Application Number (SSI-5414)

**Re: Response to the North West Rail Link (NWRL) - Environmental Impact
Statement 2 (EIS2)**

Figure 6.12 Cherrybrook Station - Indicative vehicle and pedestrian movements

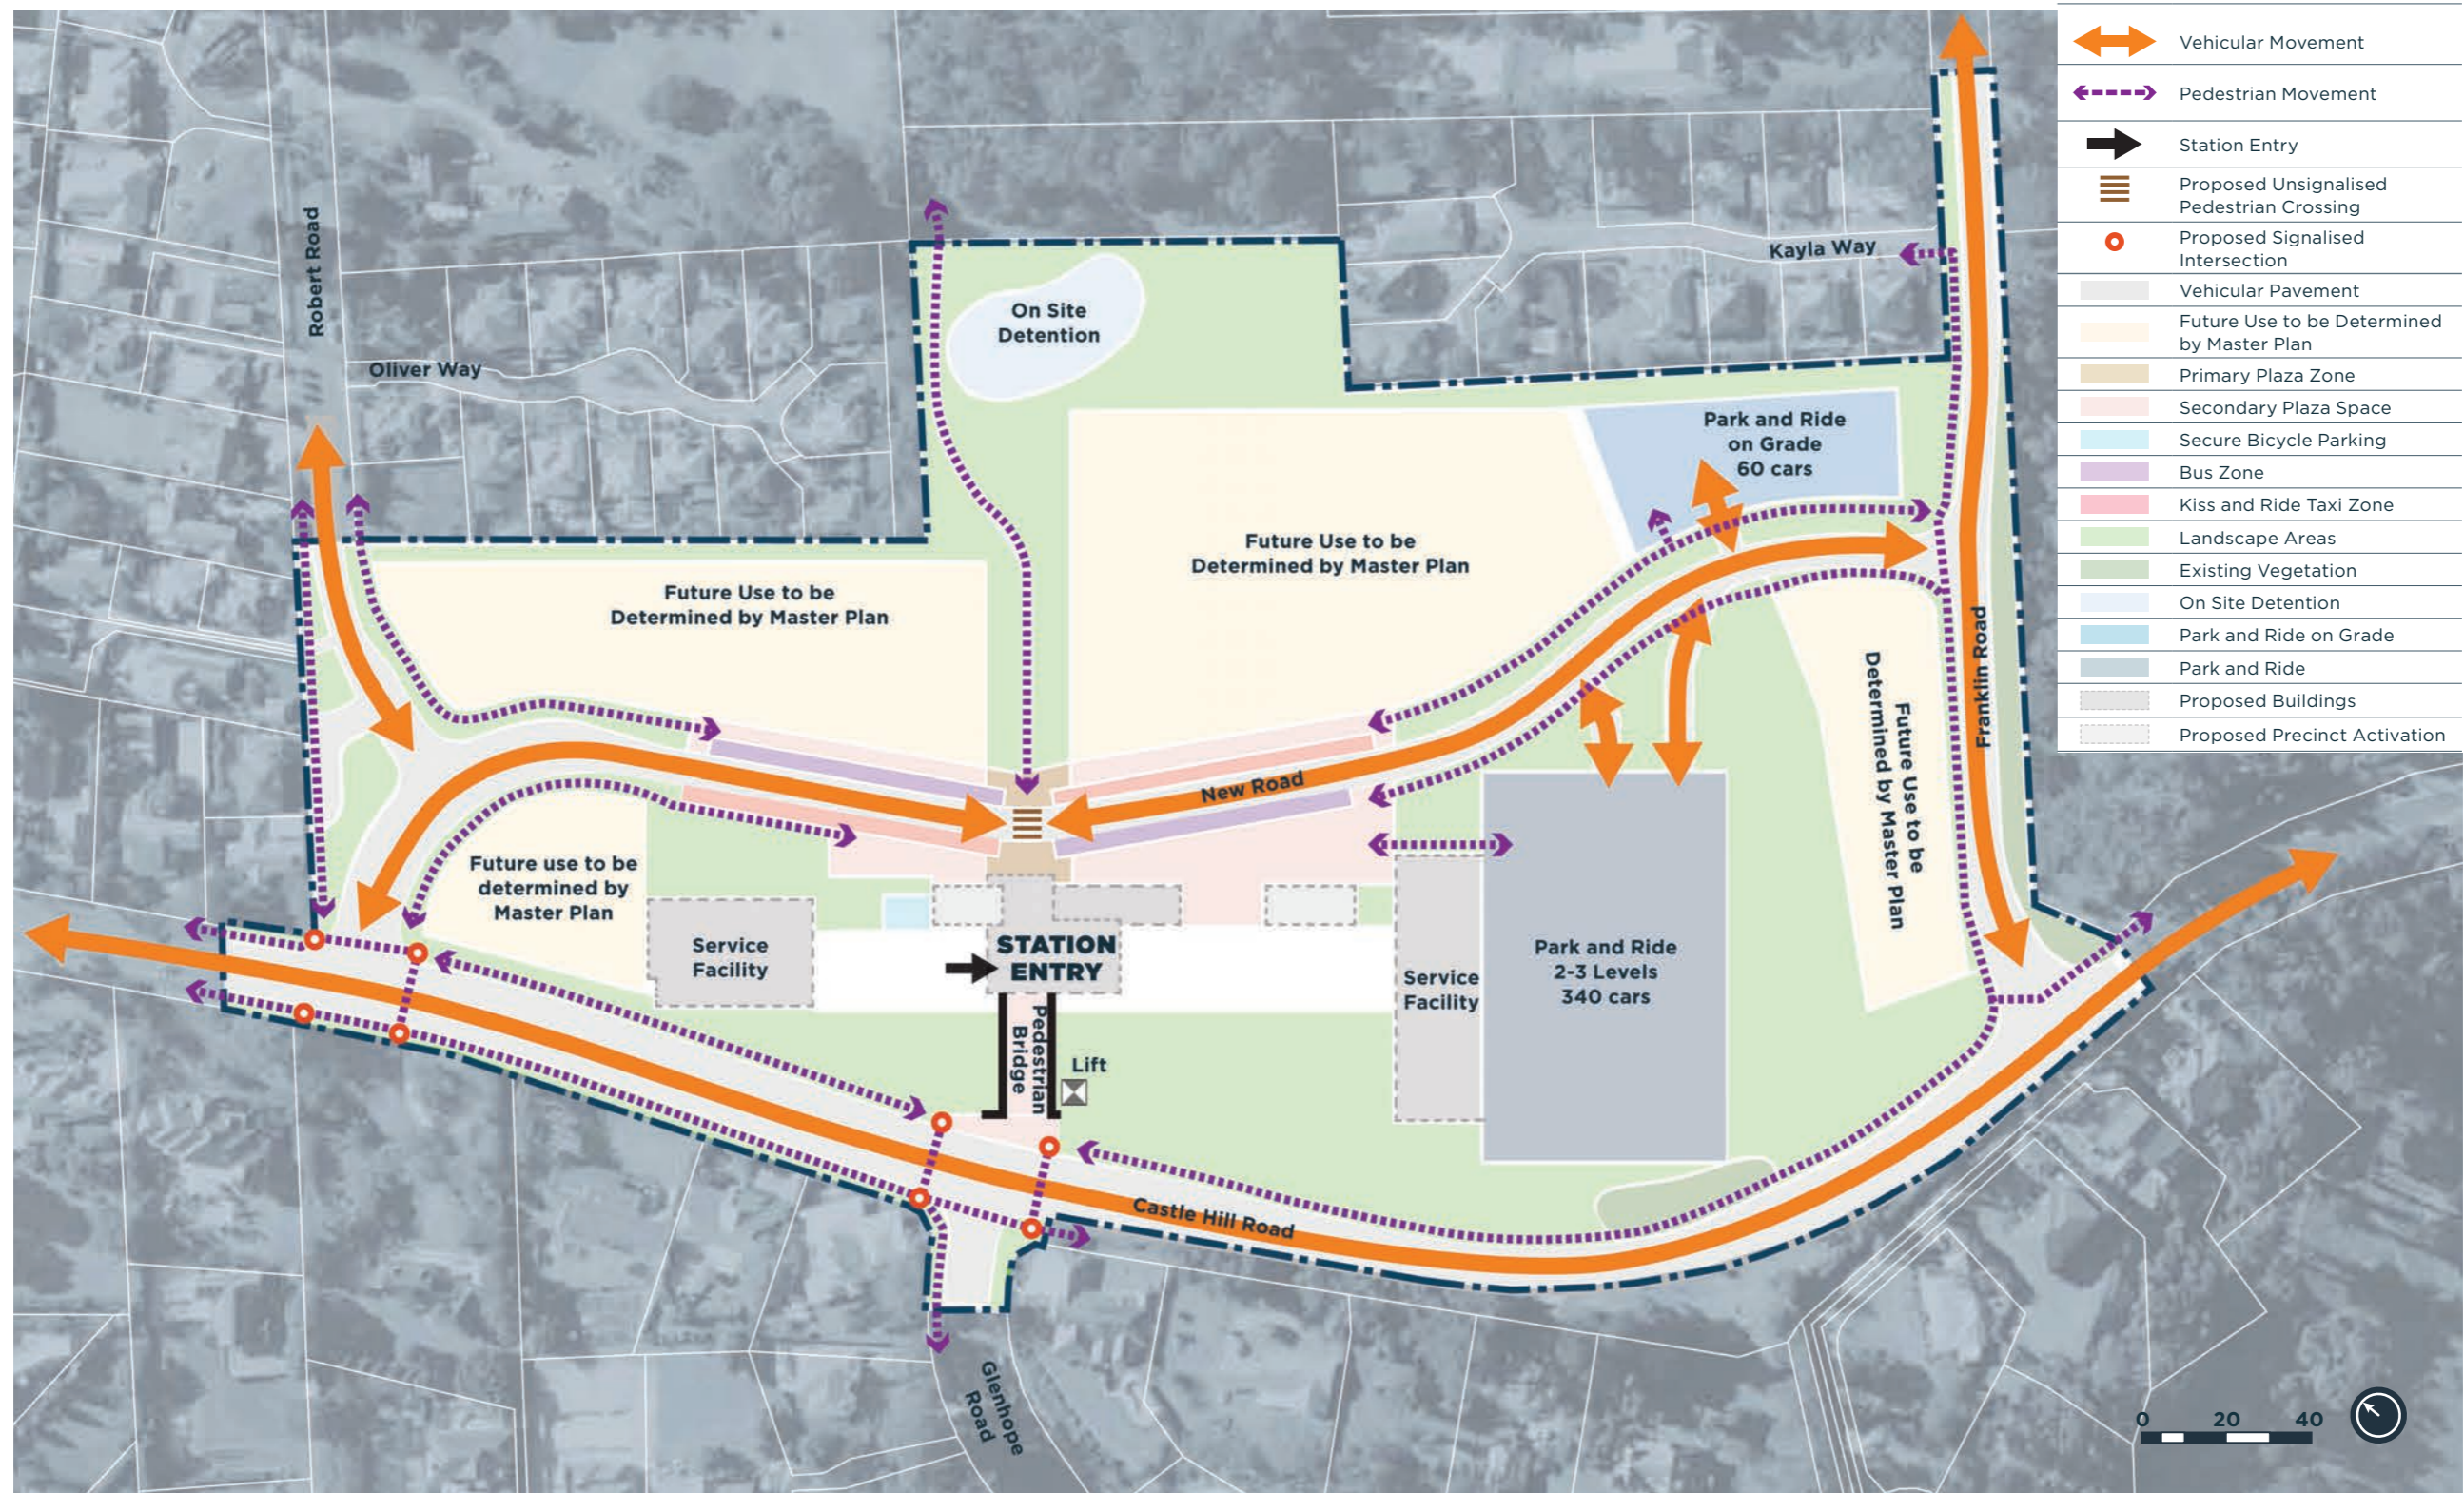
I wish to lodge an objection to changes being proposed to the use of Robert Road as an access point for the former Franklin Road Station (now Cherrybrook Station).

The environment coming from increased traffic flow
Safety issues as Robert Road was not designed for heavy traffic access
Removal of off-street parking particularly impacting several community estates
Loss of amenity due to increased noise & pollution
Resultant loss of property values despite the close proximity to the new station

Based on my experience as a long term resident, any additional traffic in Robert Road be it cars or buses will result in an increase in the already hazardous conditions and hence a significant reduction in the relatively safe residential environment currently experienced by residents.

There already exist roads in the area that have been designed for greater traffic flows and buses in particular namely John Road, County Drive, Franklin Road, Neale Ave, Edward Bennett Drive and Castle Hill Road and that previous traffic management changes have been designed to achieve that outcome. The suggestion that Robert Rd would become a no parking road either side whilst County drive (already designated a major road) would continue to allow kerb side lane parking instead of four lane traffic is beyond comprehension. As a regular morning and evening user of the County Drive/Castle Hill Road intersection it is clear that the left lanes turning into Castle Hill Road are largely empty so the argument that County Drive lacks capacity to access the station via Castle Hill Road in my opinion lacks validity.

It would seem the move to use Robert Road has only come about because of the extension of the construction zone westwards because of the power line easement near Franklin Road. Given that these power lines pass over many properties I fail to understand why they have become an issue for this railway station. Further if this has been done to enable some other as yet unknown developments (high rise) to take place in the future then I would oppose any such developments being considered as they don't fit in with properties already in the area.

I therefore wish to place on record my opposition to any changes to Robert Road from its current position as local suburban road providing access for local residents either during the construction period, or subsequently after the railway station development has concluded.
